M3 Junction 9 Improvement

Scheme Number: TR010055

7.12.7 Statement of Common Ground with Cycle Winchester

31 July 2023

DRAWING TITLE  
 FIGURE 2.6 - THE SCHEME: TEMPORARY DIVERSION OF WALKING, CYCLING, AND HORSE RIDING ROUTES APFP REGULATIONS 5(2)(a) DOCUMENT REFERENCE 6.2

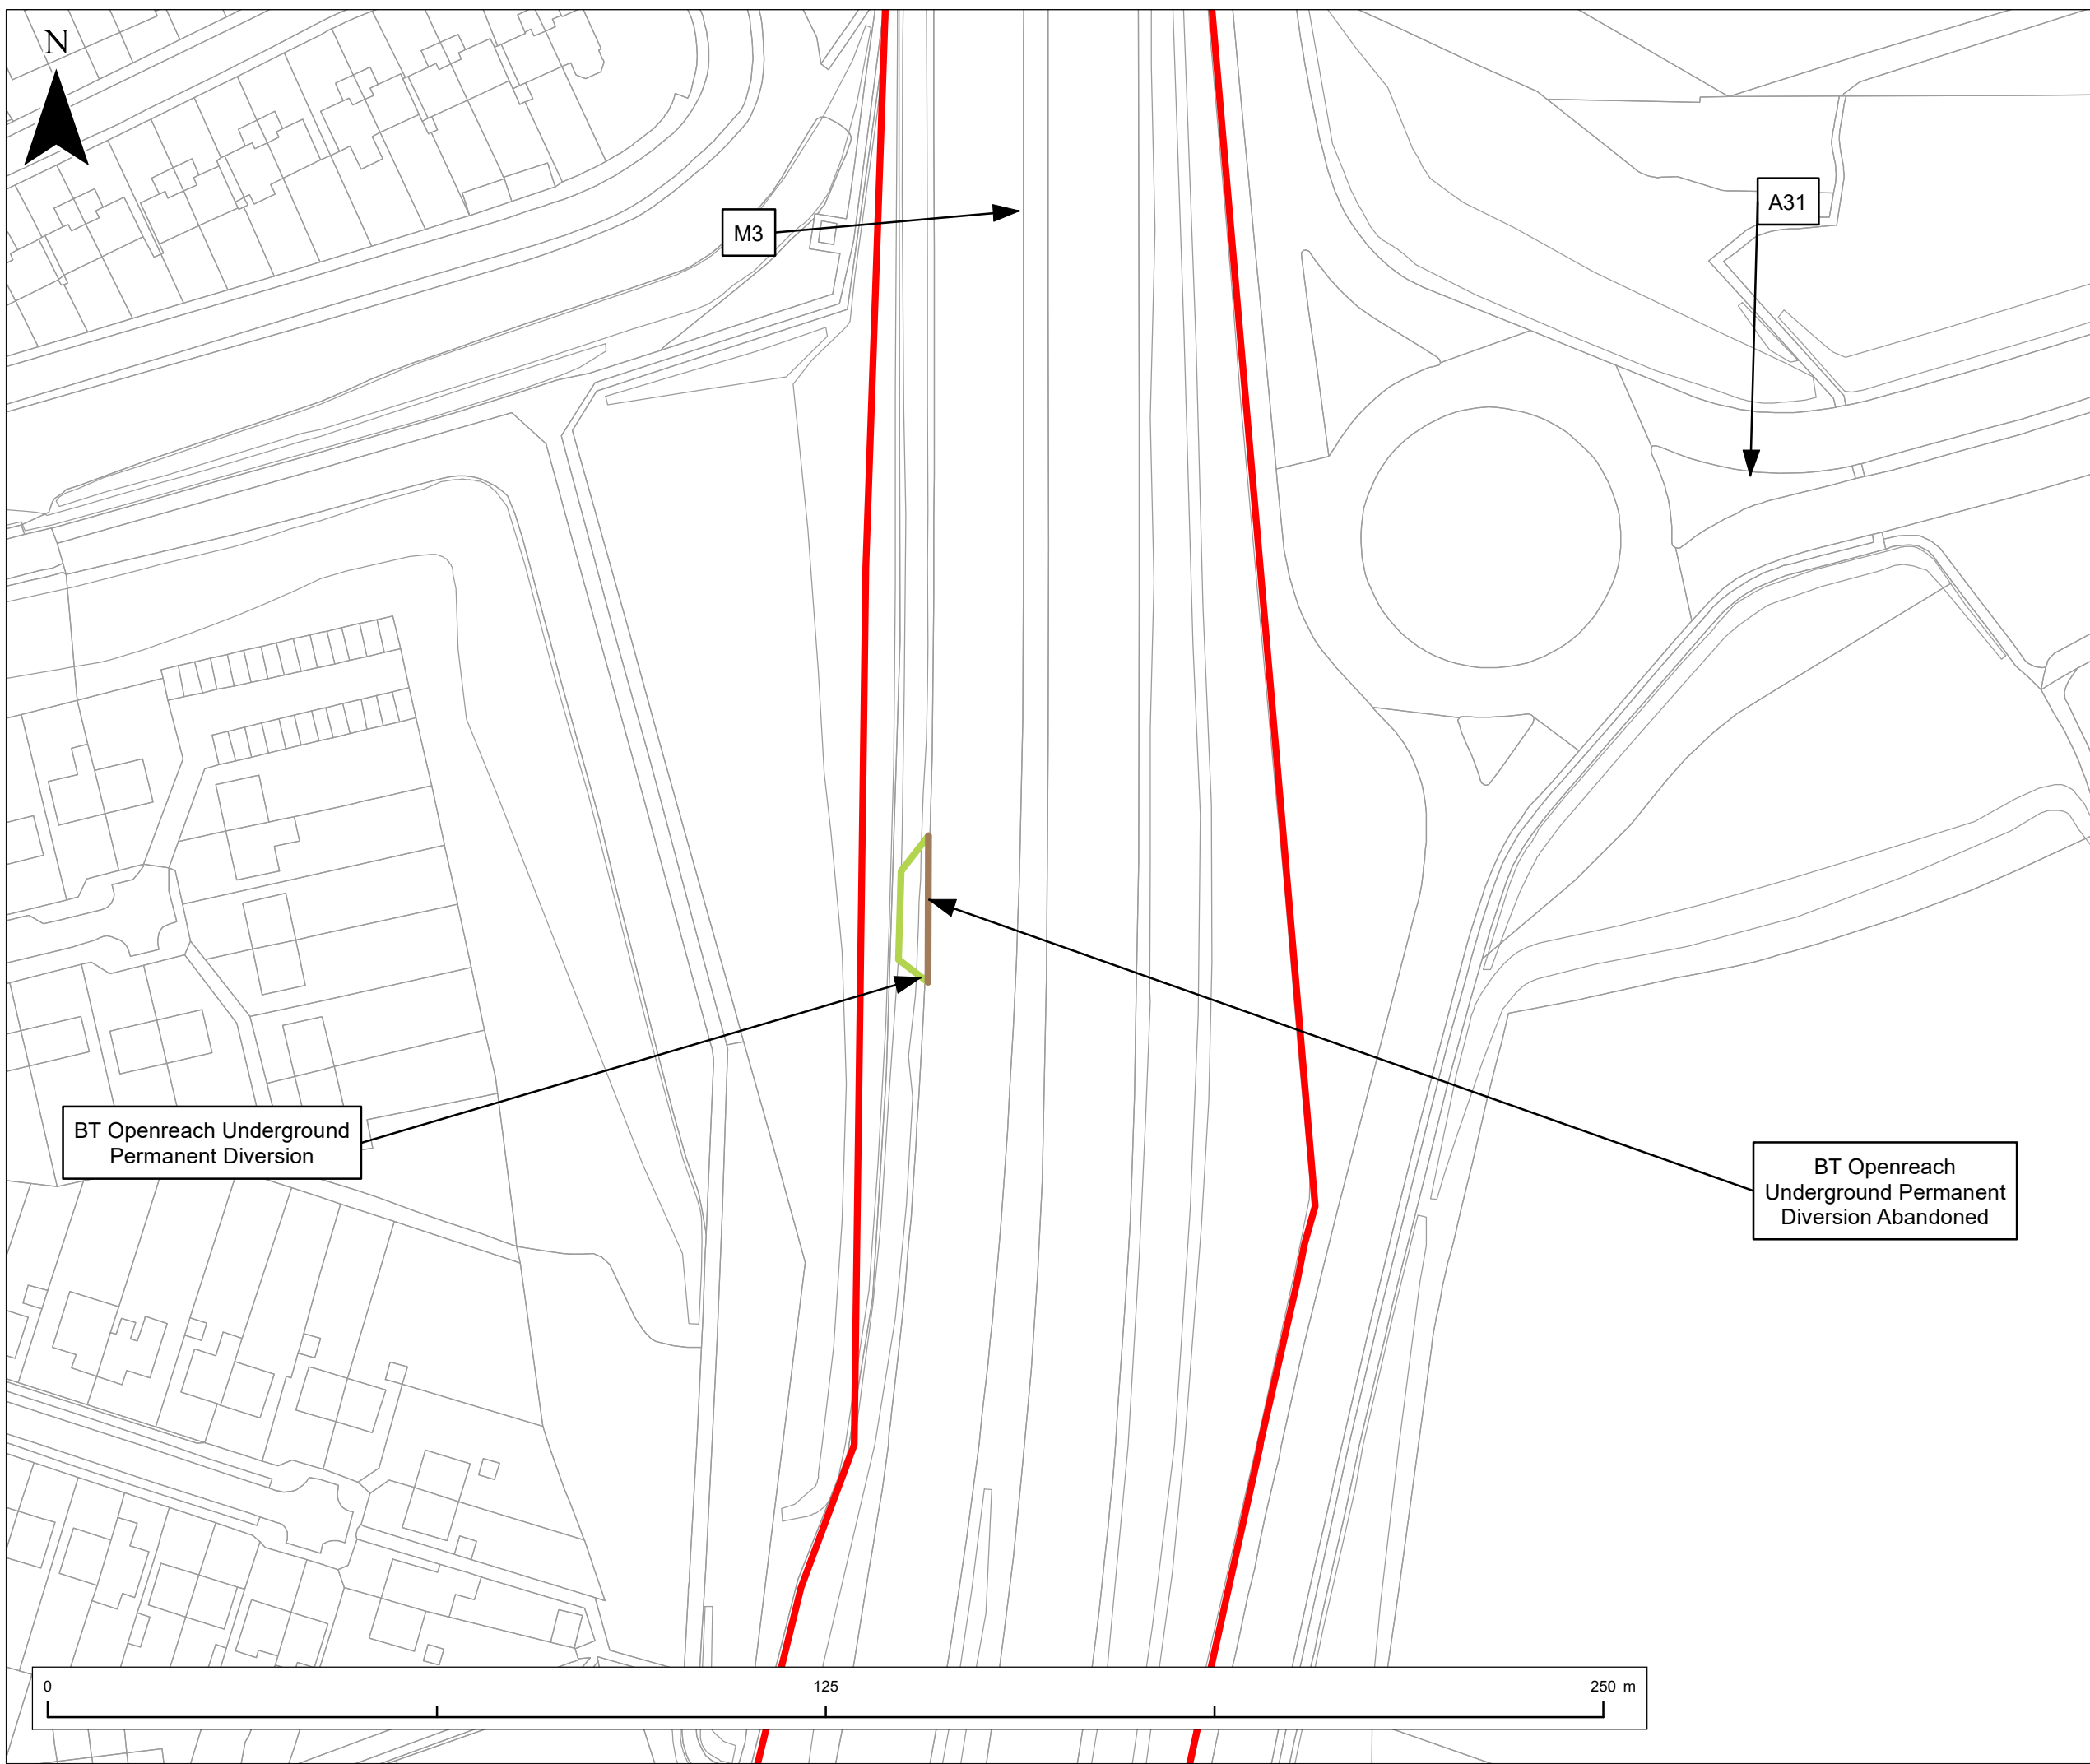
5. Traffic Management Plan						
5.1	NCN Route 23 Diversions during construction	Figure 2.6 (Temporary diversion of walking, cycling and horse-riding routes) of Chapter 2 (The Scheme and its Surroundings – Figures (Part 3 of 4)) of the ES (6.2, APP-063) and Chapter 12 (Population and Human Health) of the Environmental Statement (ES) (6.1, APP-053)	<p>Although the NCN23 route is not used to its full potential, it is heavily used by local cyclists and alternative routes will be needed and mitigation measures required. The diversion route proposed in the DCO submission (Table 12.25 of Chapter 12 (Population and Human Health) of the Environmental Statement (ES) (6.1, APP-053)) is both illegal and physically impossible for cyclists and equestrians to use. Despite many opportunities (and many requests), the National Highways project team failed to discuss it with the WCH consultative group before submitting the proposal. There's no way Cycle Winchester can agree to it.</p> <p>Two possible diversion routes are:</p> <ul style="list-style-type: none"> Long Walk, Fair Lane and Alresford Road (B3404), and Easton Lane and Martyr Worthy Road (B3047). <p>Alresford Road is busy and hostile to cyclists and so National Highways should be looking at funding mitigation measures to make it more suitable as an alternative cycle route. Cycle Winchester note that the project team considers Alresford Road to be a safe diversion route without further mitigation. Based on real-world experience, we disagree. It is a busy road with fast-moving traffic, relatively narrow vehicle lanes and no cycle facility. While it is true that some short sections of NCN Route 23 use national speed limit roads, these are all quiet country lanes with very low traffic levels and physical characteristics that make high driving speeds impossible in practice.</p> <p>Cycle Winchester would like to see an open discussion of diversion routes and agreement</p>	<p>Figure 2.6 (Temporary diversion of walking, cycling and horse-riding routes) of Chapter 2 (The Scheme and its Surroundings – Figures (Part 3 of 4)) of the ES (6.2, APP-063) shows two temporary diversion routes for NCN Route 23.</p> <p>Chapter 12 (Population and Human Health) of the Environmental Statement (ES) (6.1, APP-053) is being updated to make the diversion routes clearer.</p> <p>The route for cyclists diverted from the eastern side of the gyratory during construction phases 1 and 2 would be along Long Walk, Fair Lane and then west on Alresford Road as per the first suggested option in the comment. Neither of the diversion routes are illegal or impossible for cyclists and equestrians to use and National Highways does not consider it necessary to undertake any works before they can be used.</p> <p>The diversion route on Alresford Road contains an approximately 100m stretch under national speed limit before the limit decreases to 40mph. The diversion route for NCN Route 23 will be clearly signposted and monitored and checked during its implementation. Further mitigation is not needed for this diversion because currently NCN Route 23 contains section of national speed limit roads. Mitigation will be reviewed during construction and implementation of the diversion route.</p>	Under discussion	31 July 2023
